CITY OF ALBUQUERQUE

**RE: 5179 Golondrina NW
Grading and Drainage Plan
Engineer's Stamp Date: 05/25/2026
Hydrology File: F11D005A
Case # HYDR-2026-00062**

Based upon the information provided in your submittal received 02/26/2026, the Grading and Drainage Plan **is not approved** for Grading Permit and Building Permit. The following comments need to be addressed for approval of the above referenced project.

ENGINEER'S SEAL	114 AMENDED TRINITY RANCH ADDITION 5179 GOLONDRINA NW GRADING AND DRAINAGE PLAN	DRAWN BY MM
		DATE 2-24-2026
3/12/26	ALBUQUERQUE, NM 87199 (505) 321-8099	SHEET # C1
DAVID SOULE P.E. #14522		JOB #

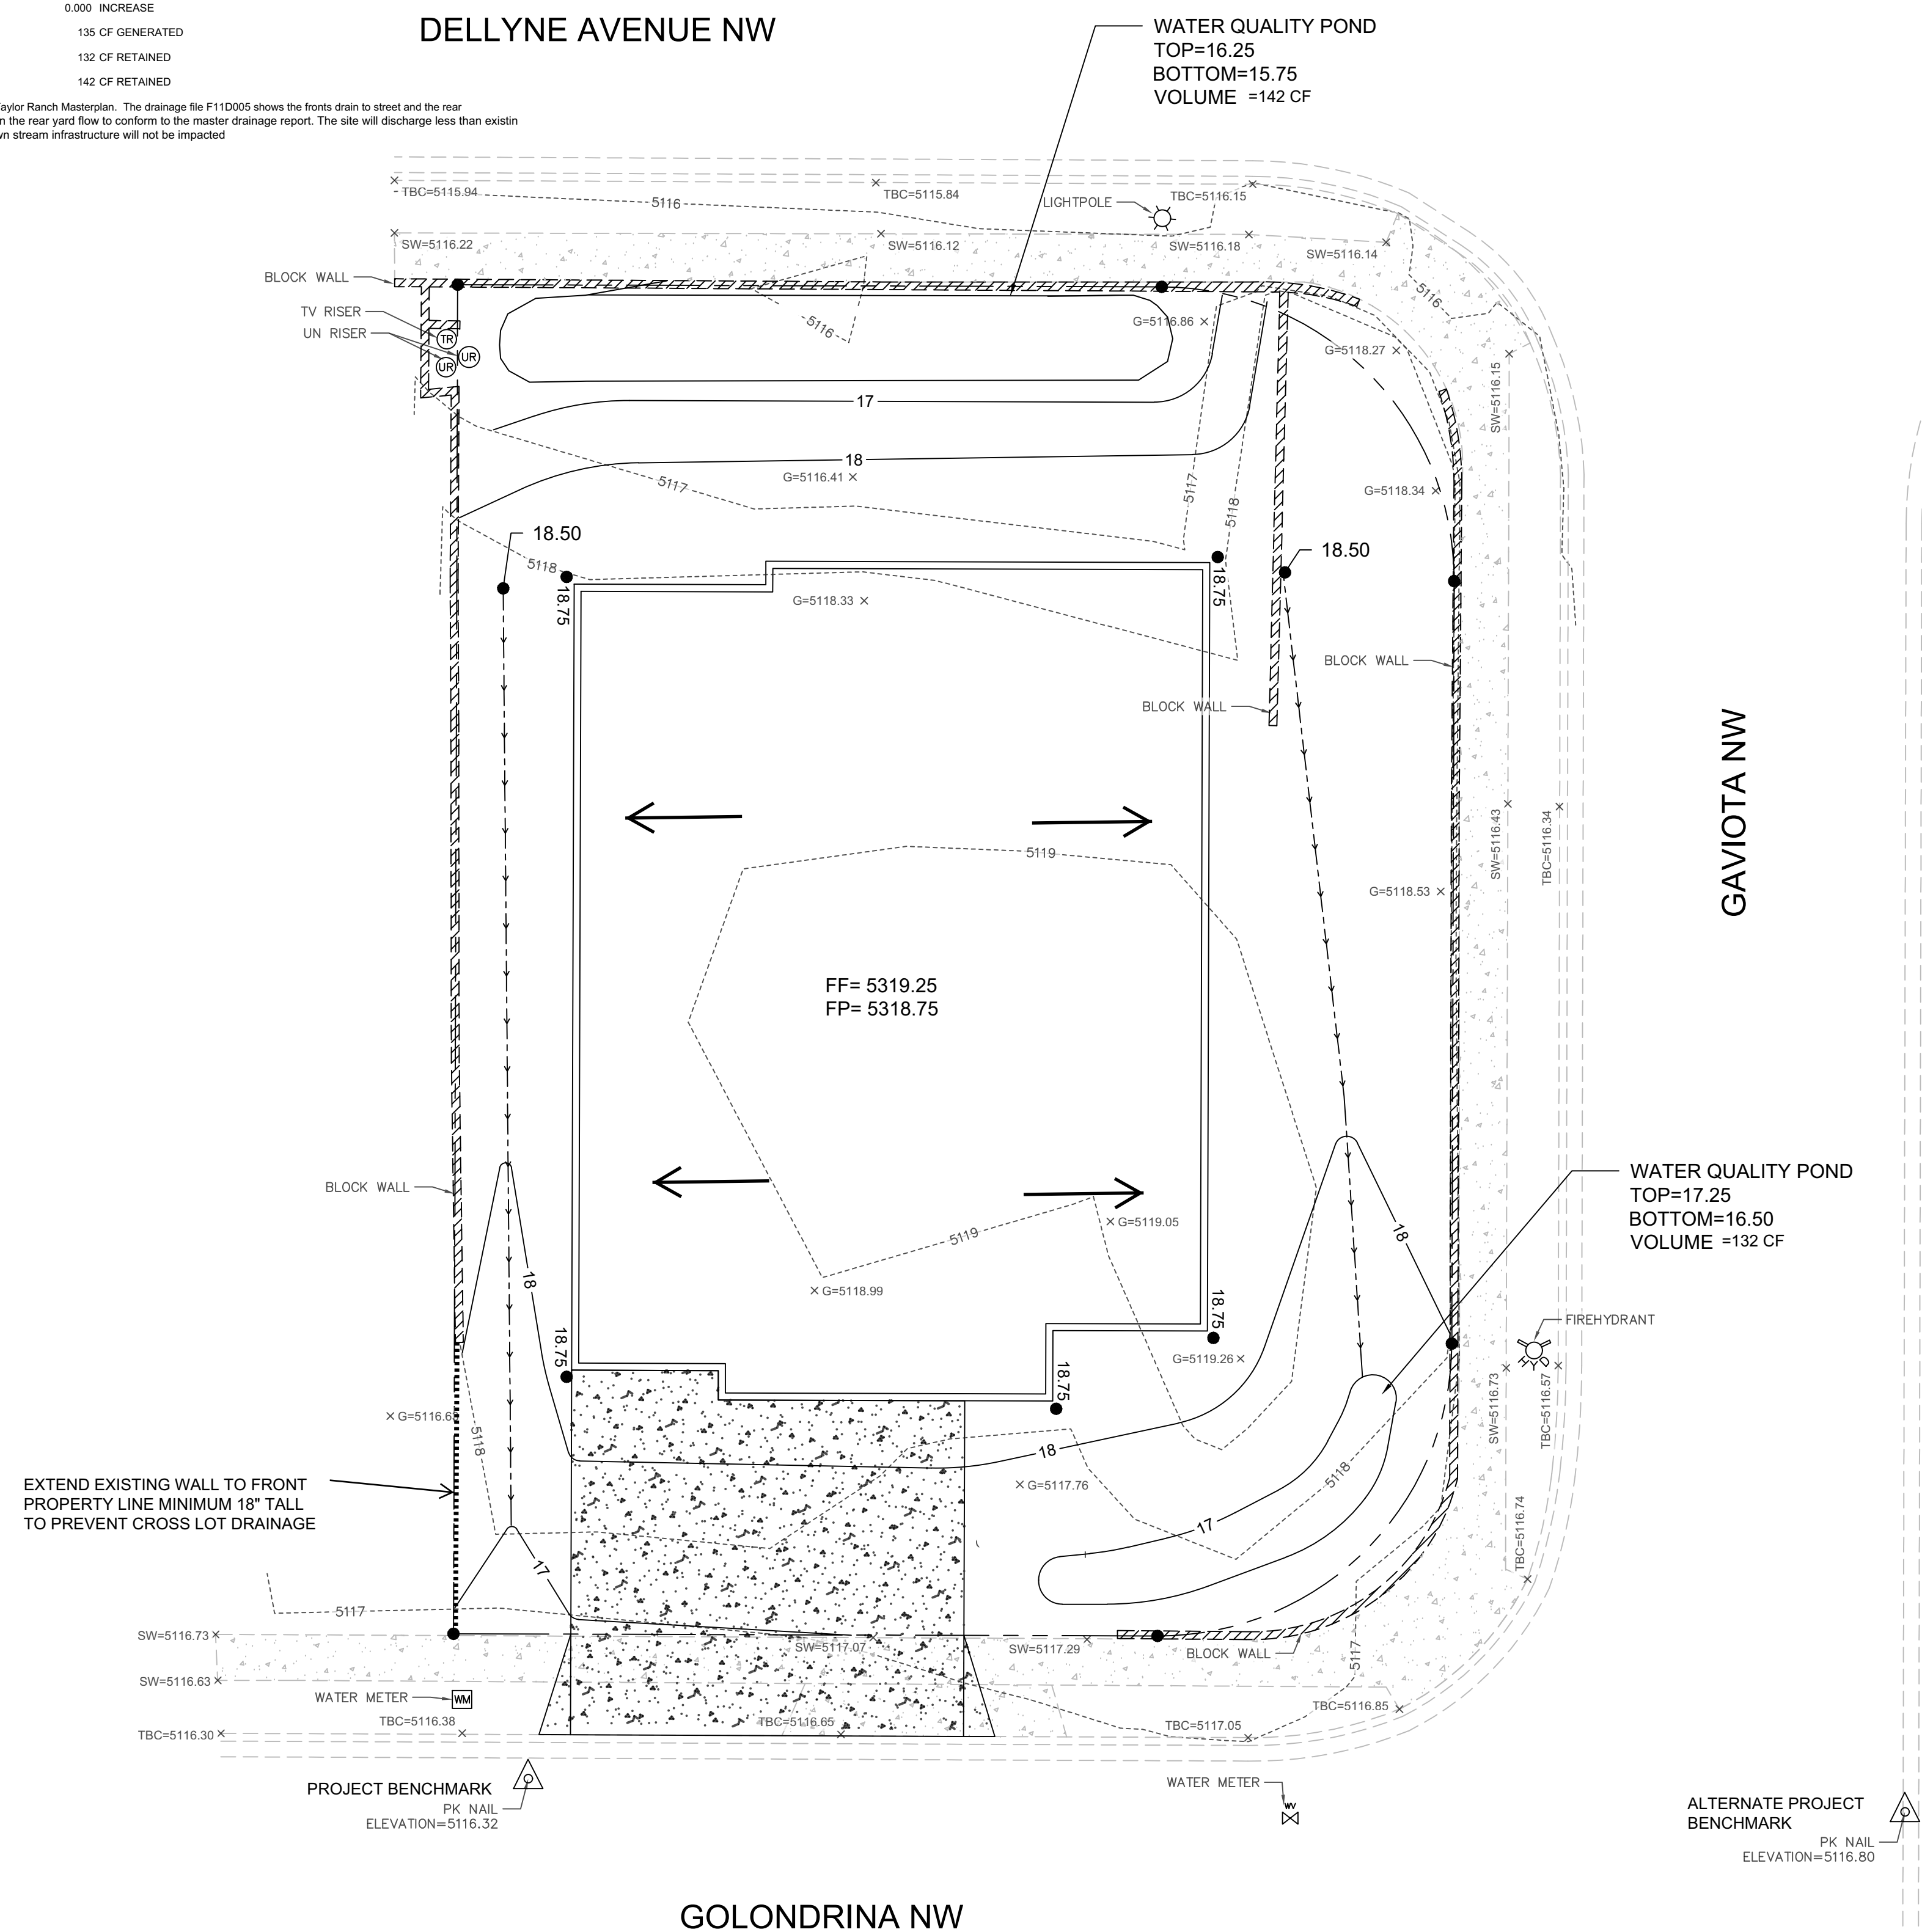
1. Please extend the wall all the way to the south property line or provide a barrier to contain the stormwater to the property for conveyance to the right-of-way.

2. Include project benchmark and datum.
3. Remove note #5. A pad certification is not required for this site.
4. Add the floodplain note with effective date.
